Application No: BR/44/21/PDH  
Site Address: 38 Havelock Road Bognor Regis PO21 2HA  
Description of works: Notification under extended permitted development rights for a single storey rear extension with mono-pitch roof & roof lantern measuring 8m from beyond the rear wall of the original dwelling house, with a maximum height of 3.8m and eaves height of 3m

Thank you for your internet representation made on 3rd March 2021 which has been recorded as an objection with the comments as follows:

Proposed Rear Elevation 1:100

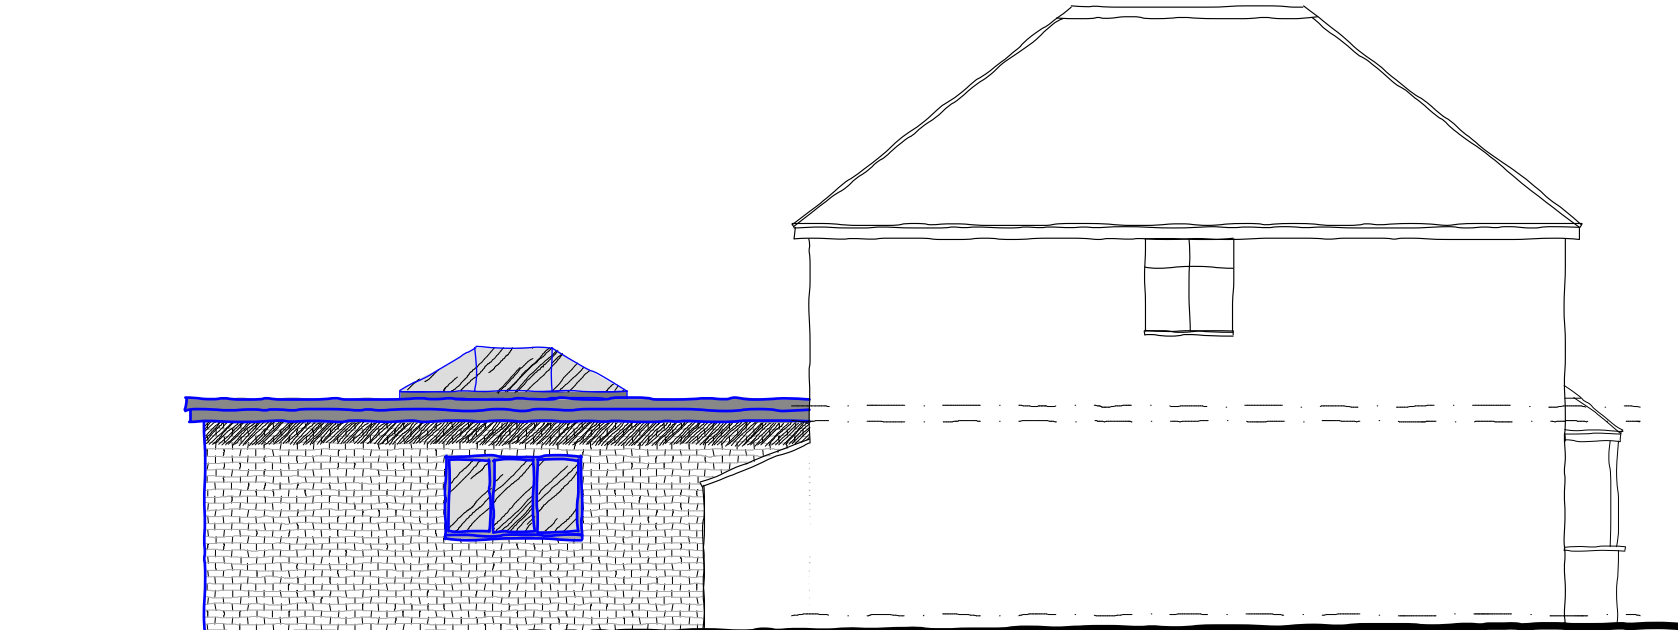
I object to this application as I live at no.40 Havelock Road and this extension will block out direct sunlight to half my garden after 3pm in the summer. My right to light is affected. Please at least consider reducing the height of the roof lantern. Also I object as there is no consideration being taken for sustainable drainage as flash flooding could be an issue as this extends the plot over the garden by 53.6m<sup>2</sup>. If someone were to place tarmac over the same area I am sure there would be many objections due flash flooding issues arising.
